Your Ref: OWPC26713
Our Ref: M/25/20/HH 26-03-2020
Please ask for:
Zac Denton

Single story rear extension and detached garage to the front.
120 Middleton Road Middleton-On-Sea

Representations of Middleton on Sea Association in respect of Planning Application M/25/20/HH - 120 Middleton Road, Middleton on Sea.

DRW NO 10A SCALE 1/500 (A3)
BLOCK PLAN

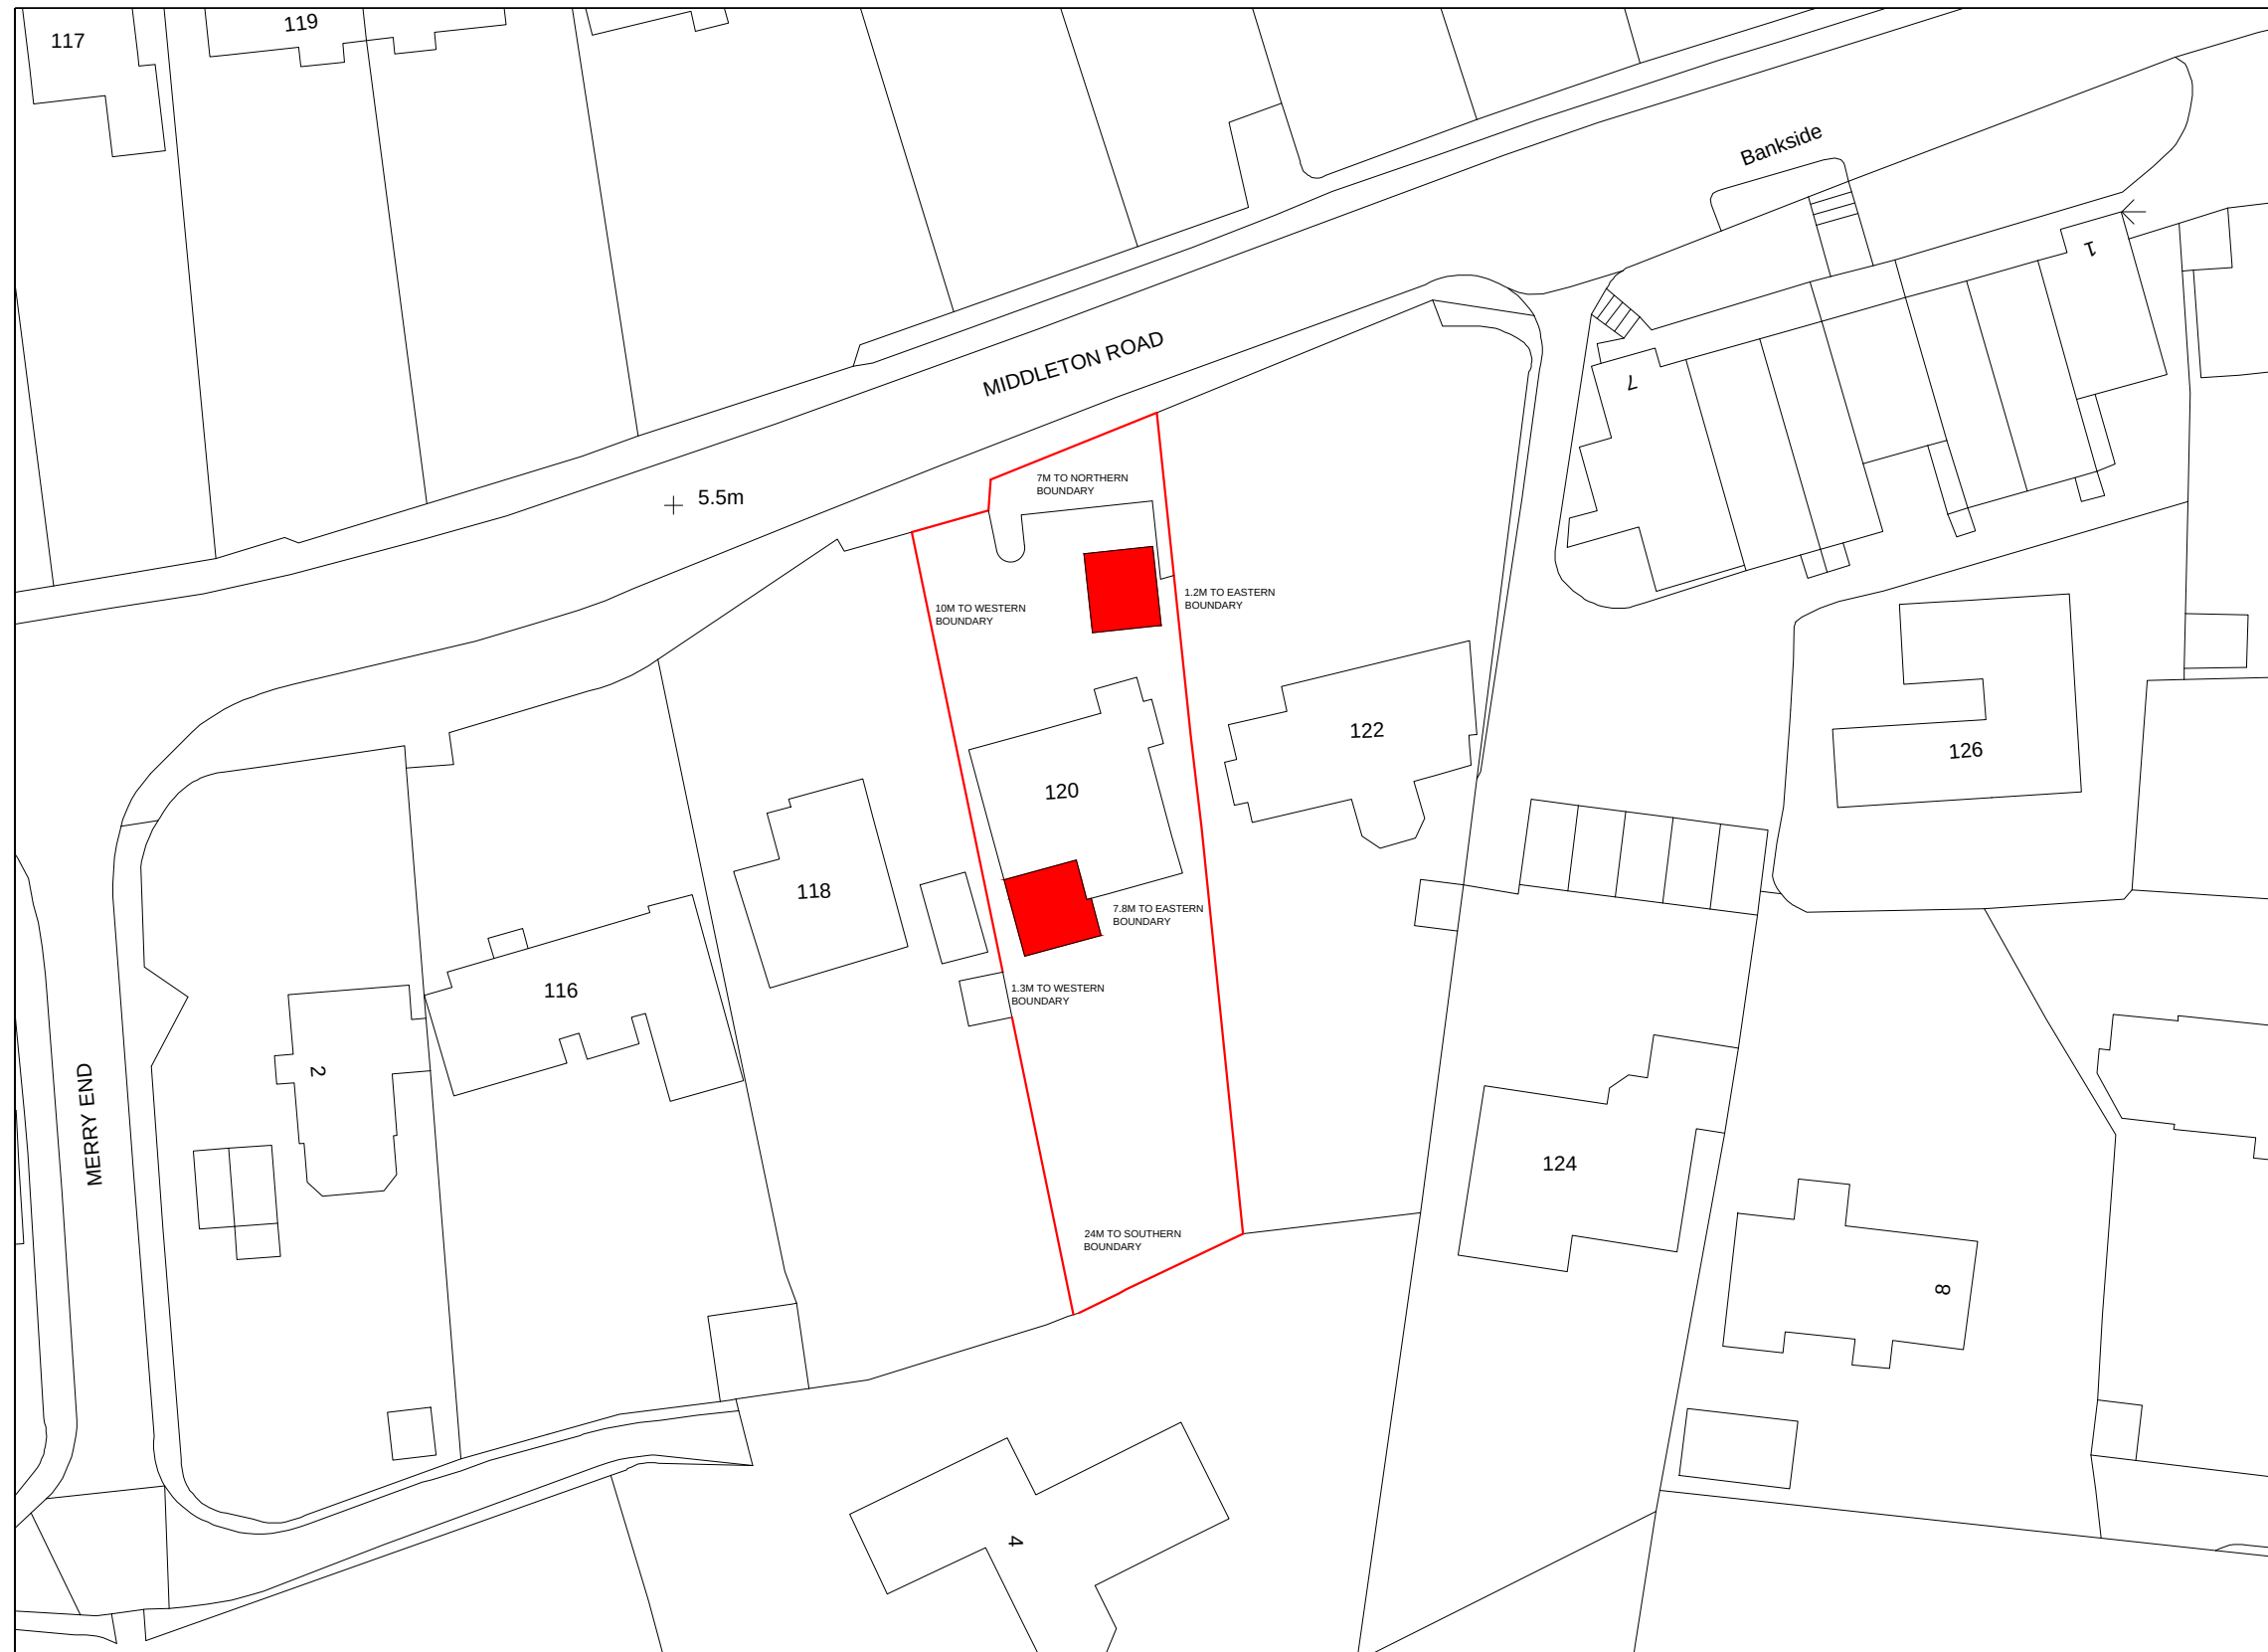
Whilst not opposing the proposed rear extension to the living space of 120 Middleton Road, MOSA objects to the proposed Garage/Workshop sited within the front garden which it considers to be in conflict with the philosophy behind the adopted Middleton-on-Sea Village Design Statement and the designated Area of Character.

The property was recently significantly extended and now benefits from an integral garage. MOSA's primary concern is that the proposals would introduce a new freestanding building significantly forward of the building line and create a precedent for further similar developments within this part of Middleton Road east of Merry End.
